Application Ref:	2025/005			 Ribble Valley Borough Council <small>www.ribblevalley.gov.uk</small>				
Date Inspected:	17/02/2026	Site Notice:	17/02/2026					
Officer:	EP							
DELEGATED ITEM FILE REPORT:					APPROVAL

Development Description:	Advertisement consent for 1 no. non illuminated fascia sign. 1 no. projecting sign. 3 no. window vinyls.
Site Address/Location:	Former Lloyds Bank 7 Church Street Clitheroe BB7 2DD

Sign 1 - Non Illuminated Conservation Fascia Sign - Scale 1:25

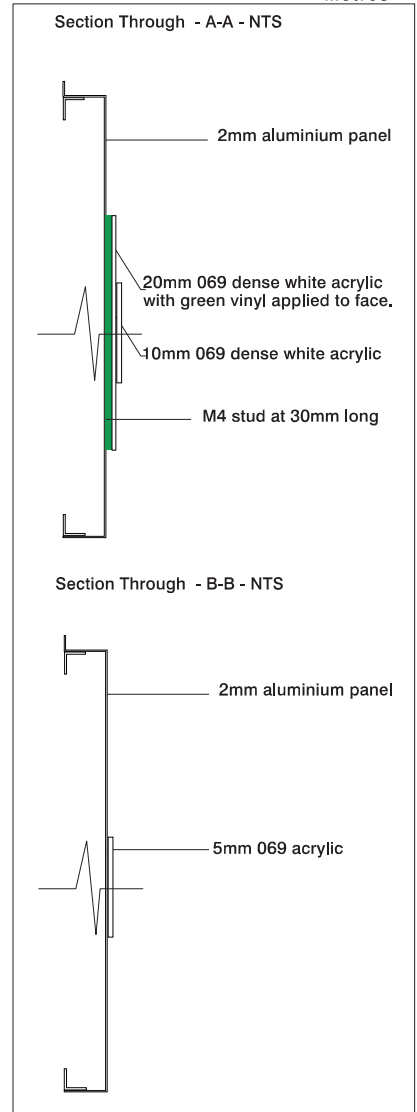
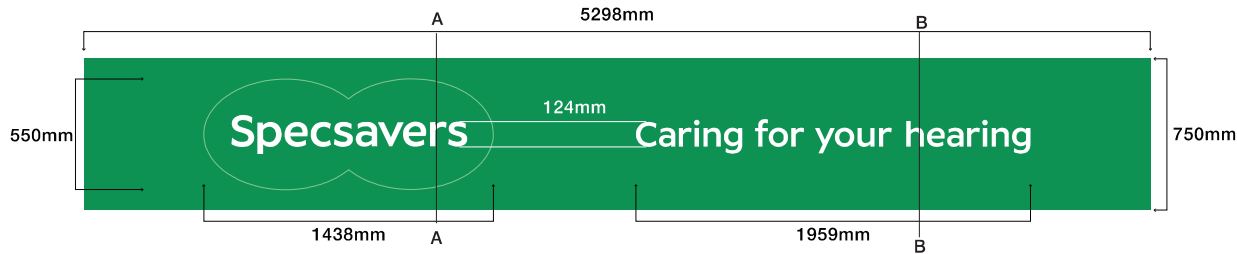
The application seeks advertisement consent for the installation of a new fascia signage to accommodate the new use/change in occupants. Following discussion, the fascia sign has been reduced in scale to reduce the visual prominence. The fascia signage will now be of a modest appearance not too dissimilar to the scale and configuration of other signage found on neighbouring properties, with the lettering considered to be well-proportioned in relation to the fascia margin. The application property is substantial in scale, the proposed sign is modest in relation and proportionate to the scale of the property. In this respect it is not considered that the proposed fascia signage will be read as being either visually incongruous nor anomalous within the immediate and wider streetscene.

Sign 2 - Externally Illuminated Projection Sign - Scale 1:10

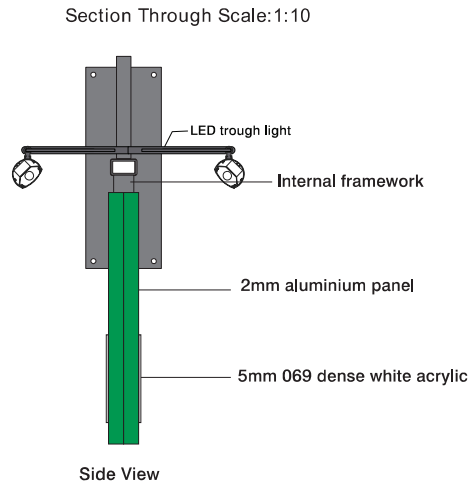
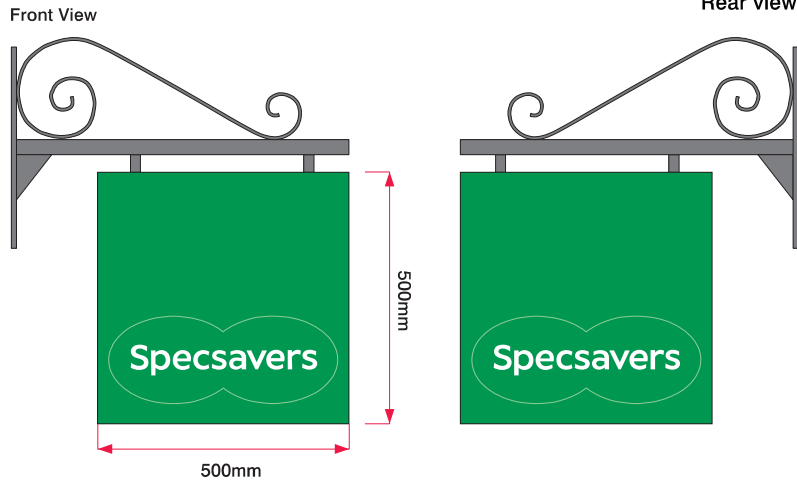
In respect of the proposed projecting signage, the submitted details propose that the signage will be of modest proportions and comparable in design to the proposed fascia signage. It was proposed that this signage would be illuminated but following discussion it has been agreed that all signs will be non-illuminated to reduce their visual prominence. In this respect the hanging signage is unlikely to result in any additional material impacts upon the character or visual amenities of the designated Clitheroe Conservation Area or the wider streetscene.

Sign 4 - Externally Applied Blank Vinyl - Scale 1:20

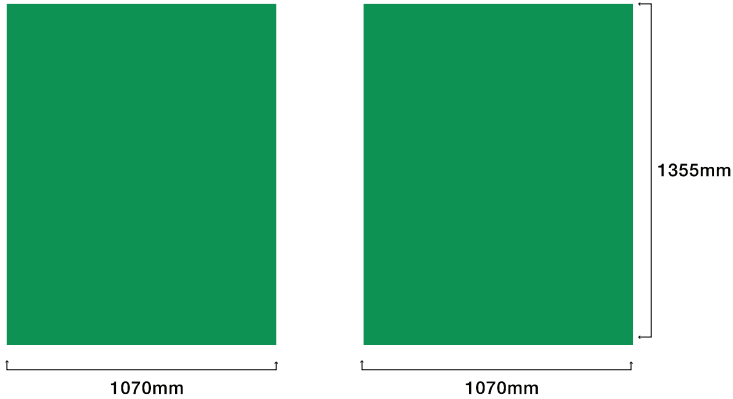
The application also involves the inclusion of vinyl sheets to allow for screening to be provided for privacy in the treatment rooms. Initially, these screens were of solid green colouring which would have resulted in an overprominent addition to the street scene of harm to the character of the conservation area, particularly when read in consort with the fascia signage. As such, the scheme has been altered to allow for one plain frosted screen with no design or colouring and one printed screen in muted colouring, to reduce their visual prominence within the conservation area.
